**SUPPLEMENTARY INFORMATION**

Site Name	Land at Tittenhurst Park	Site Address	Land southwest of Tittenhurst Park, London Road, Ascot, SL5 0PP
NGR	E: 494966 N: 168167		
Site Ref Number	95980	Site Type	Macro

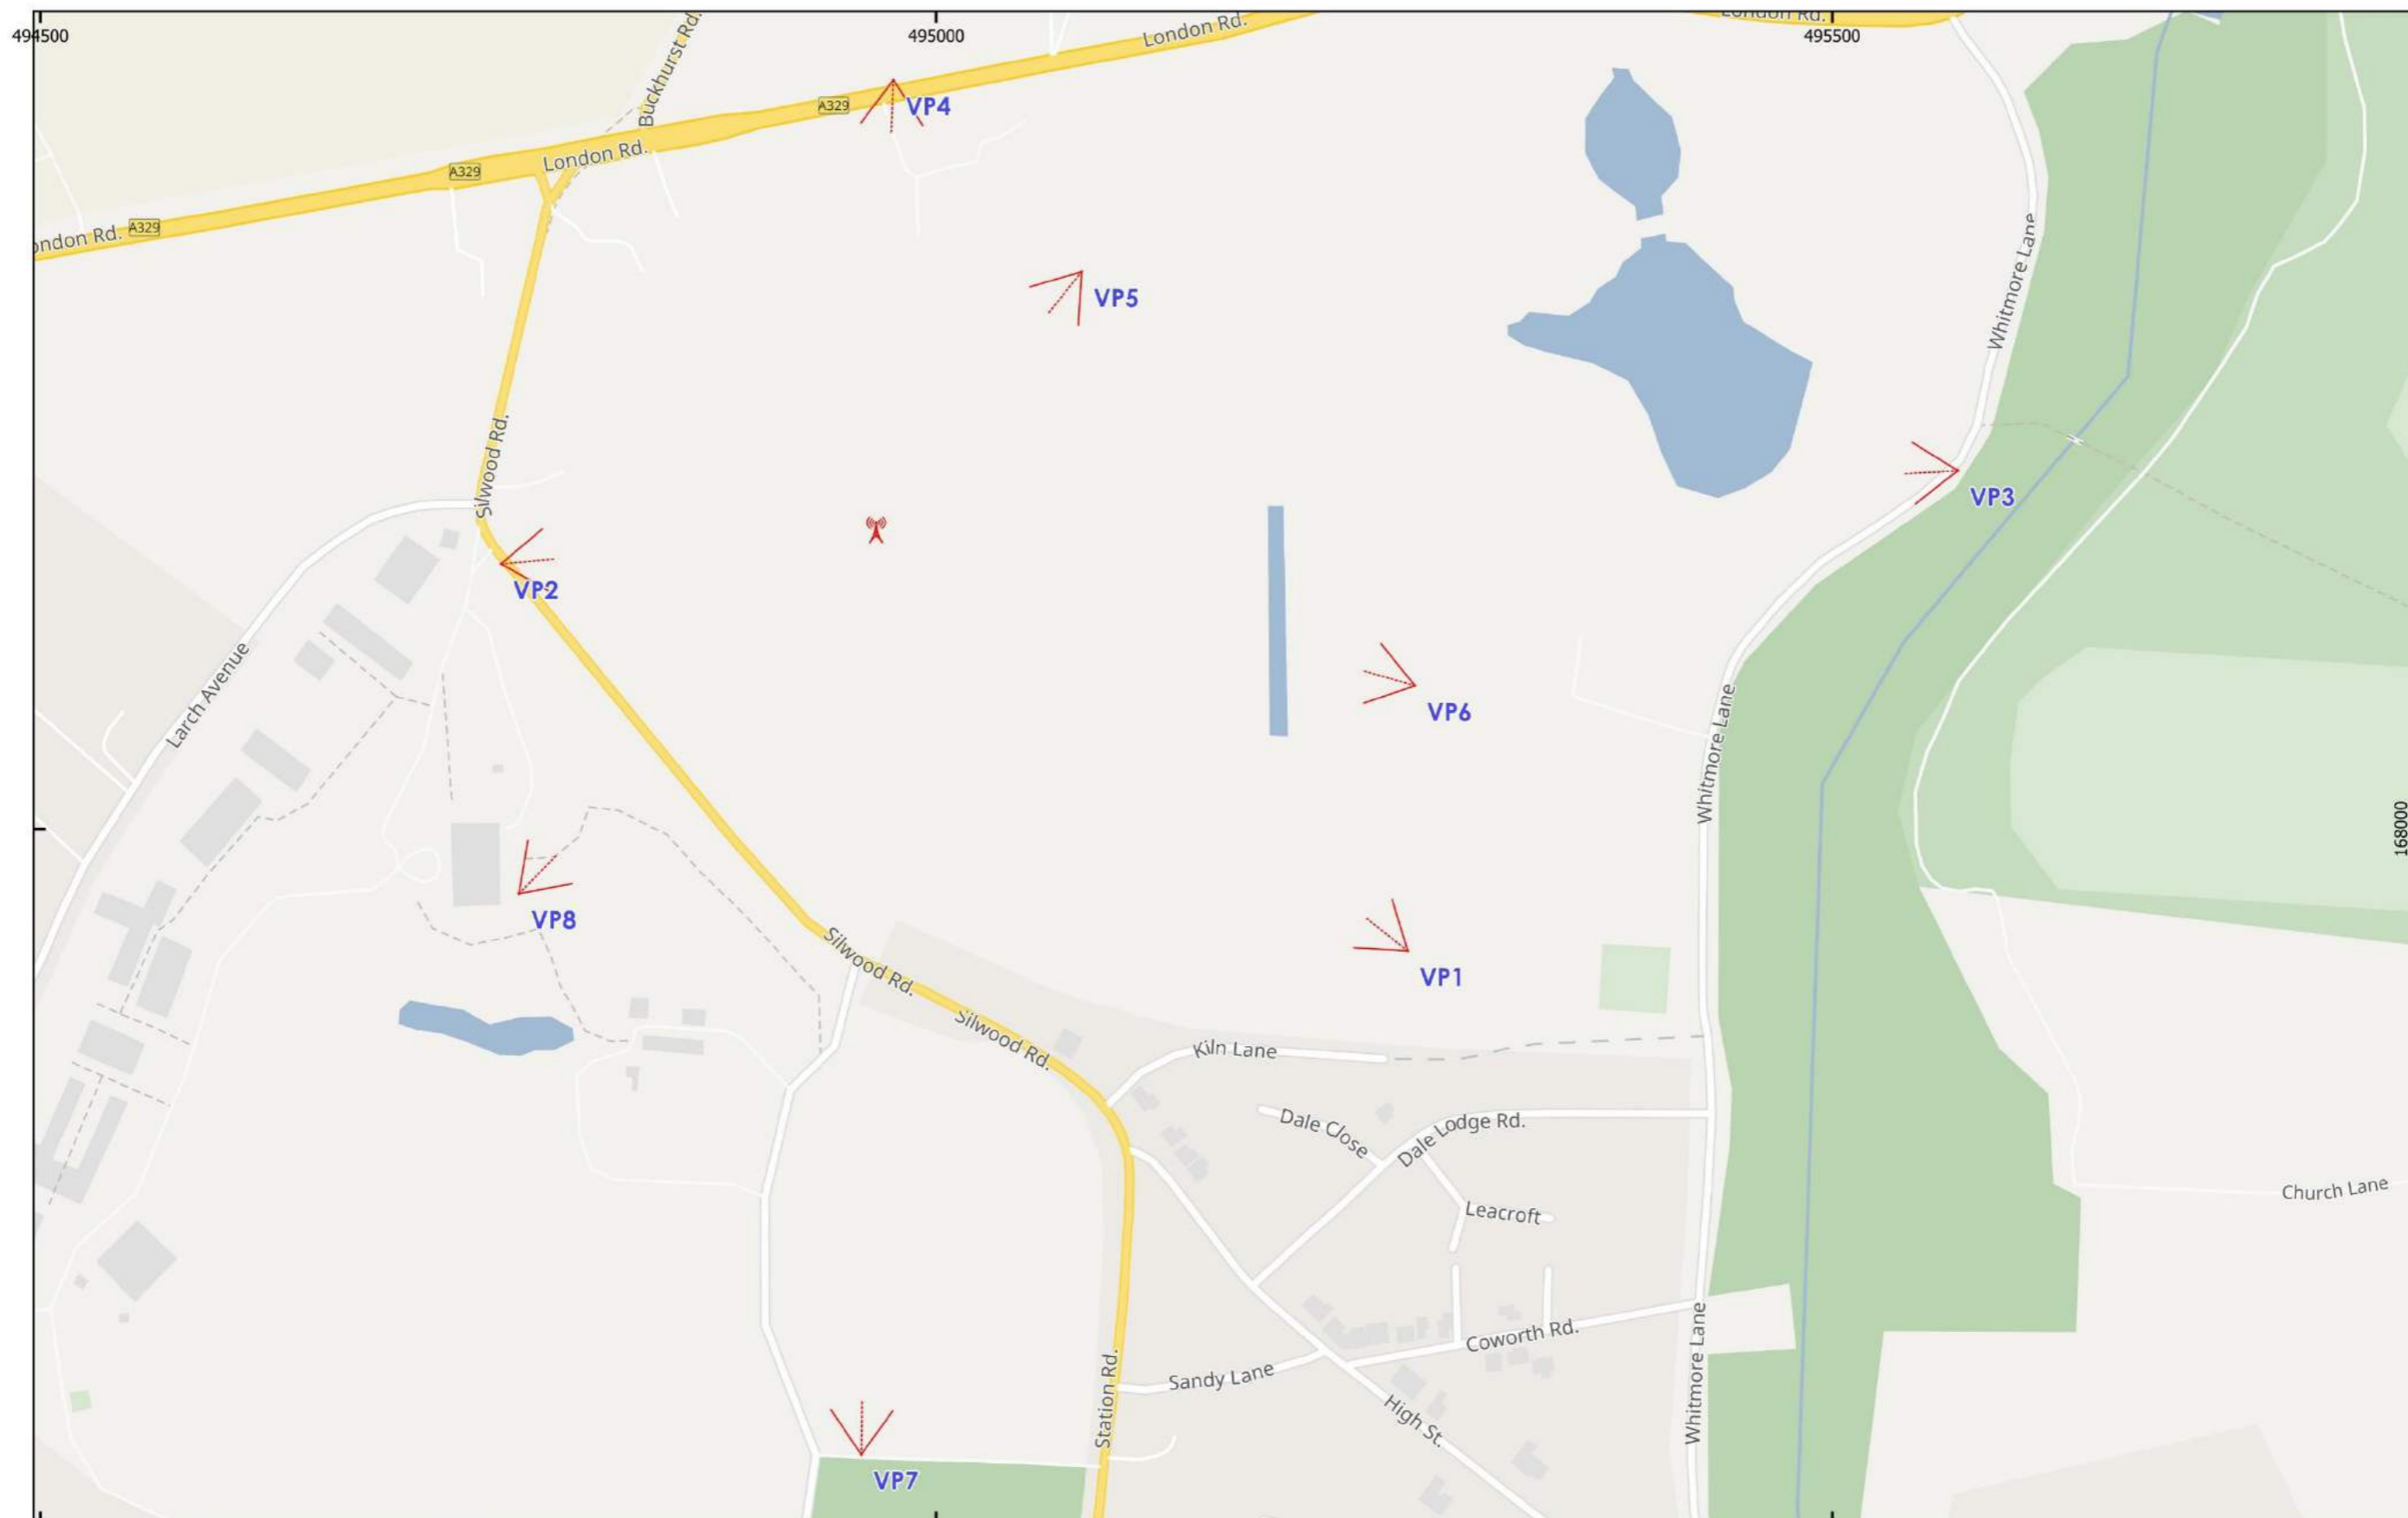
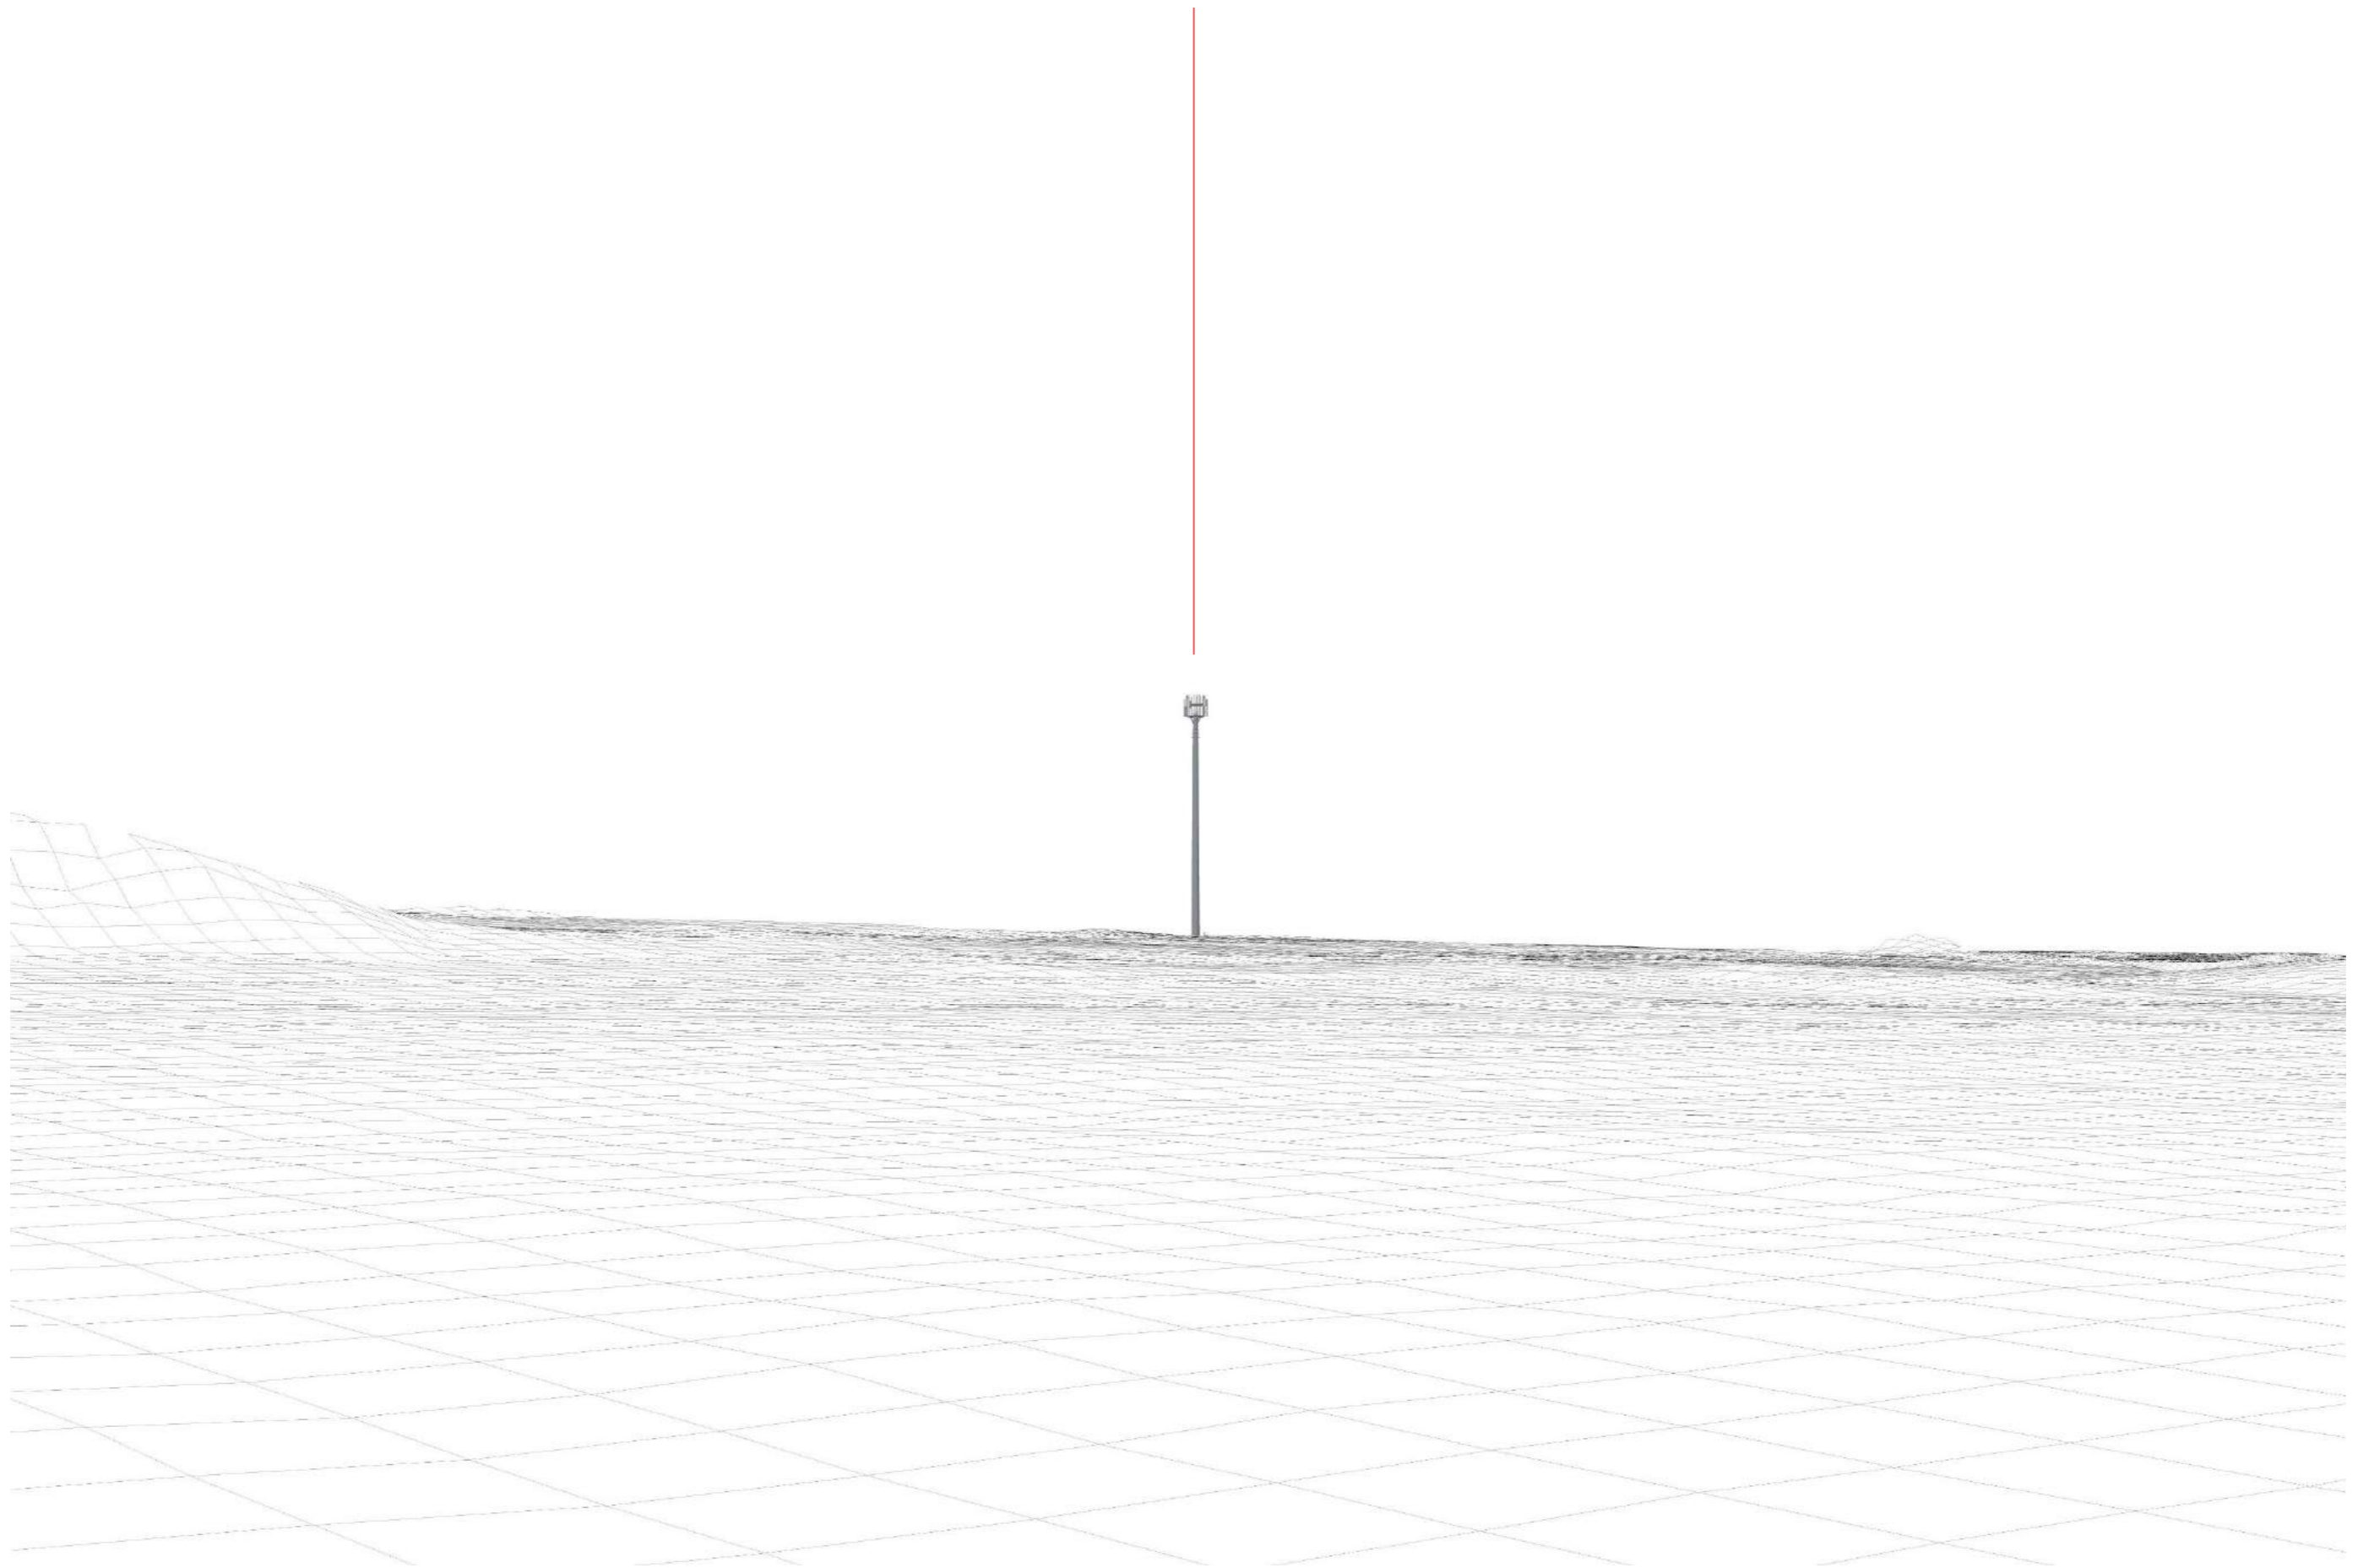
*“The impact on local character, landscape and heritage assets will be a key consideration. I note the intention to submit an LVIA but in the absence of that information we are unable to give any detailed advice on the likely acceptability of the scheme. There are some comments regarding the precedent set by the existing mast and the screening of the trees but given the proposed height of the mast I would not consider that the existing mast justifies this nor that surrounding trees would offer substantial screening. Based on information seen to date I would be concerned at the visual impact of the mast in this location.”*

Applicant Response – Given the site is located within a Greenbelt, a Photo Montage Report has been included from surrounding viewpoints. The existing mast sets the precedent that telecoms infrastructure is generally acceptable at this location in comparison to other sensitive locations in this area. Regarding the mature trees in this area, as can be seen from the Panoramic Survey Report enclosed in this application, the trees measure between 10m-30m which means there is sufficient screening for long range views when taking into account other natural vertical elements within the landscape. As demonstrated within the enclosed Photo Montage Report, visuals from public vantage points are mitigated as far as possible and the proposal is screened by trees from these viewpoints. Therefore, the visual impact from long range views is expected to be minimal on this area even given the height of 30m proposed.
